Our ref: NO/2020/112855/01-L01
Your ref: 3/2020/0601
Date: 21 August 2020

**OUTLINE PLANNING FOR THE CONSTRUCTION OF UP TO 125 DWELLINGS WITH PUBLIC OPEN SPACE, LANDSCAPING AND SUSTAINABLE DRAINAGE SYSTEM AND VEHICULAR ACCESS POINT FROM HIGHMOOR PARK. ALL MATTERS RESERVED EXCEPT FOR MEANS OF ACCESS.
LAND AT HIGHMOOR FARM, CLITHEROE, BB7 1PN**

Environment Agency position

Drawing title: Flow Exceedance Plan

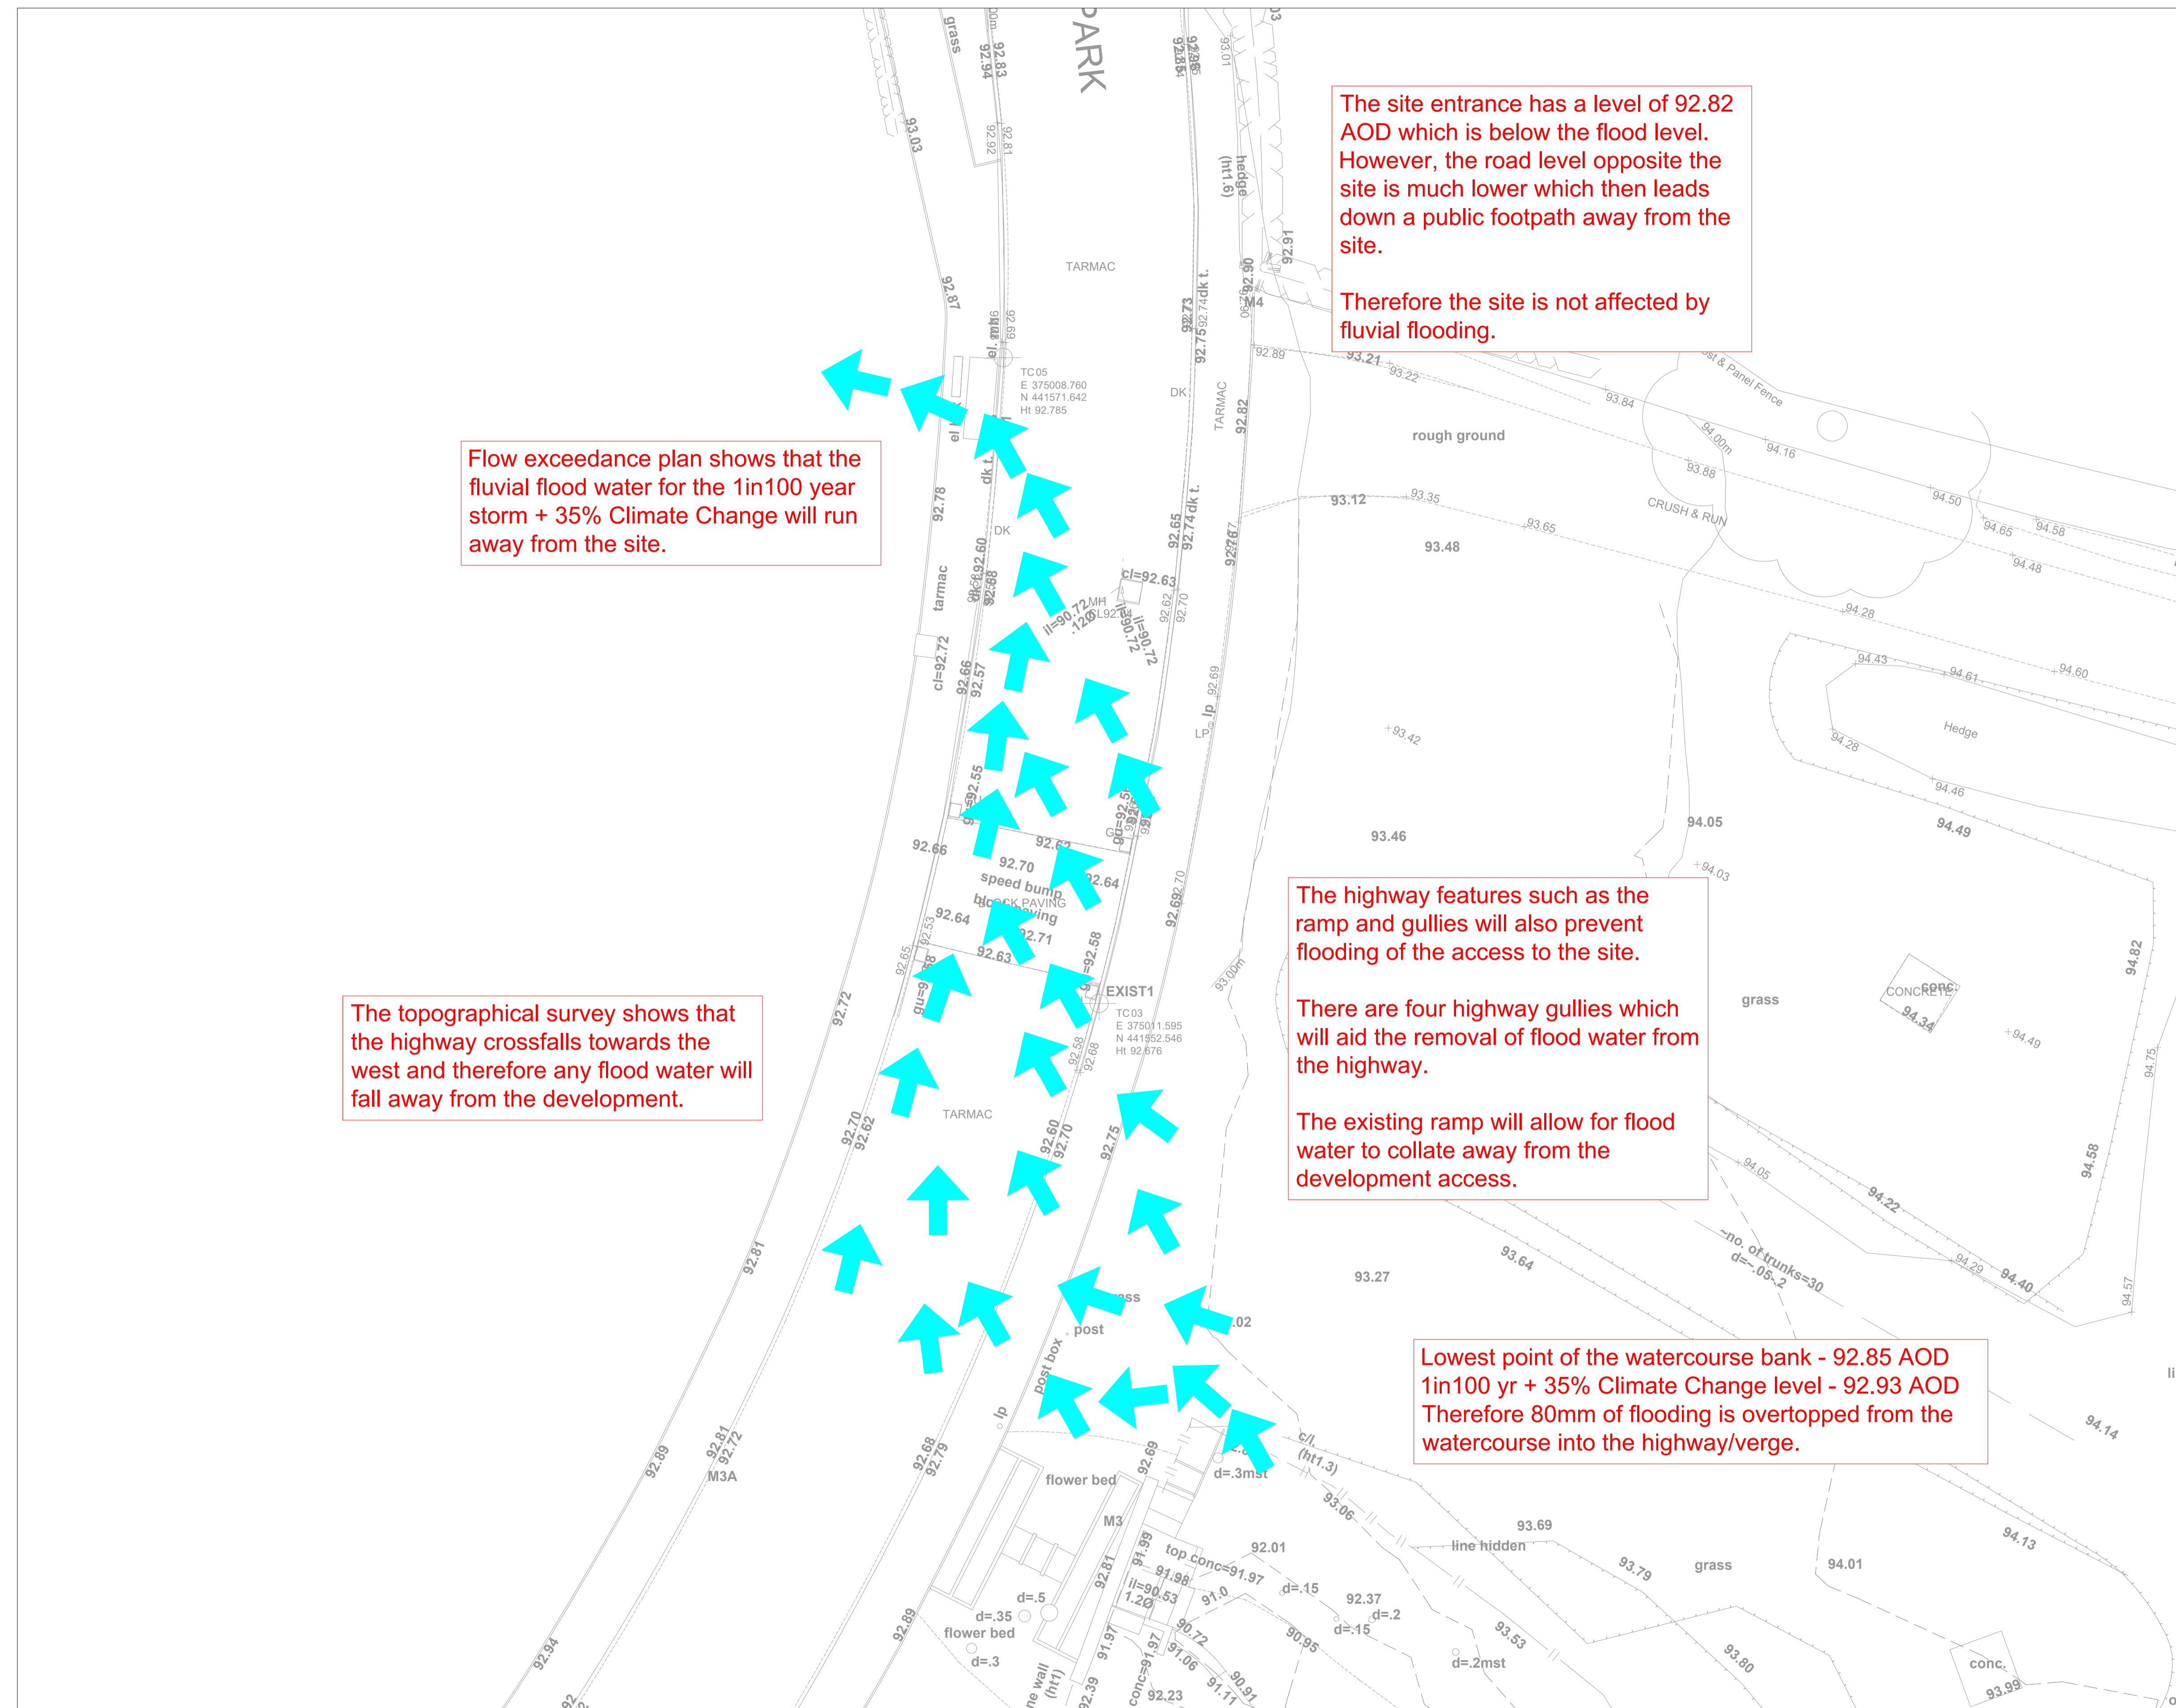
Whilst the FRA has assessed fluvial flood risk over the majority of the site, according to the Environment Agency's Flood Map for Planning, there is a small area at the point of access to the site located in flood zone 2. Due to the close proximity of Shaw Brook and the flood risk it poses to the primary access point of the site, the future flood zone 3 and therefore the impact of climate change must be assessed in more detail.

- take the impacts of climate change into account at the access point to the site

There is no assessment of the impact of climate change using appropriate climate change allowances. Further information of climate change allowances can be found in the associated PPG '[Flood risk assessments: climate change allowances](#)'. As a result there may be inadequate safe access and egress routes as the flood risk for the lifetime of the development has not been assessed.

To overcome our objection, the applicant should submit a revised FRA which assesses the impact of climate change on flood risk at the access point to the site over the life time of the development.
